Application No: AB/114/20/PD

Site Address: Riverside House 2 Fitzalan Road Arundel BN18 9JS

Description of works: Notification for Prior Approval under Schedule 2 Part 1 Class AA for a additional 2 storeys on existing dwelling house.

Drawing Title:
PROPOSED ELEVATIONS

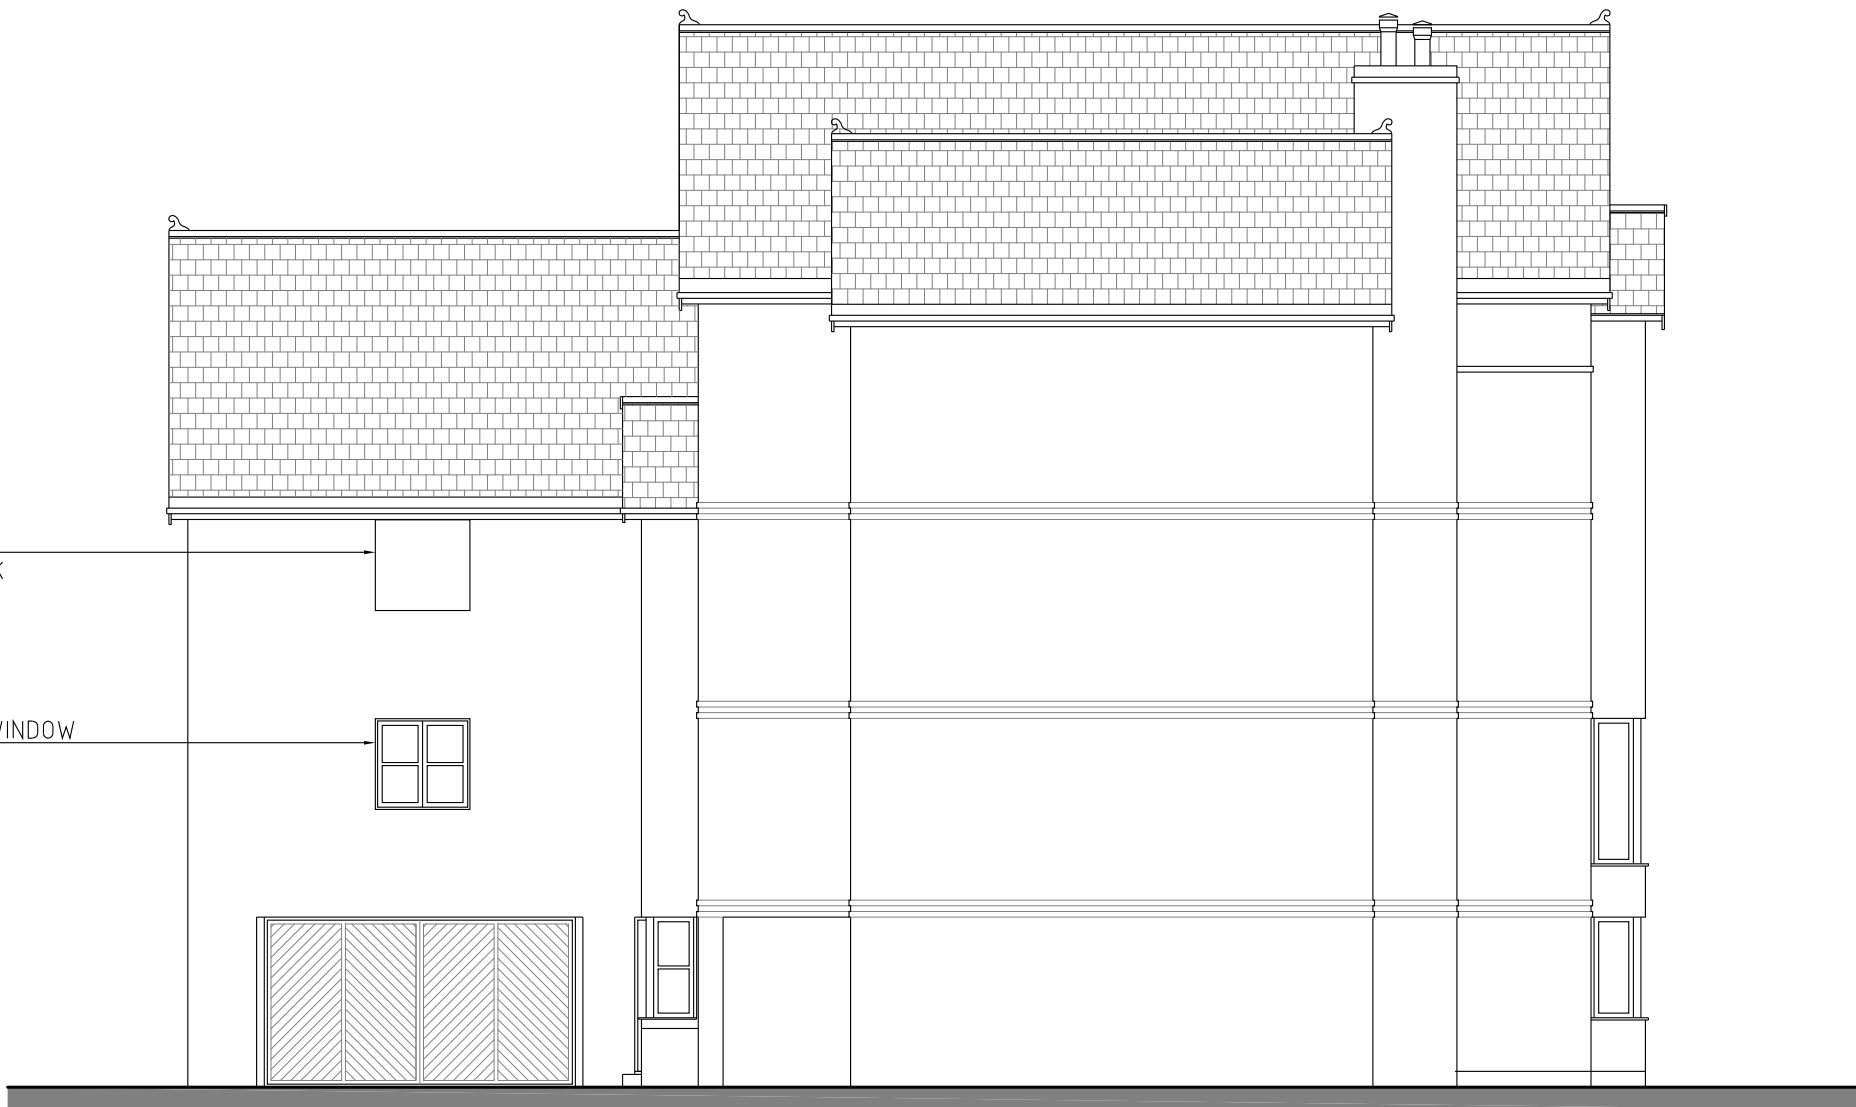
The proposed two storey extension because of its site coverage, bulk, height, proximity to the site boundaries and being located close to the Arundel Conservation Area would result in a prominent and obtrusive dwelling which would adversely affect the visual amenities and character of the area.

It would neither preserve or enhance the setting of the Conservation Area. It would therefore be contrary to policies AREA2, GEN7 and DEV19 of the Arun District Local Plan and the National Planning Policy Framework.
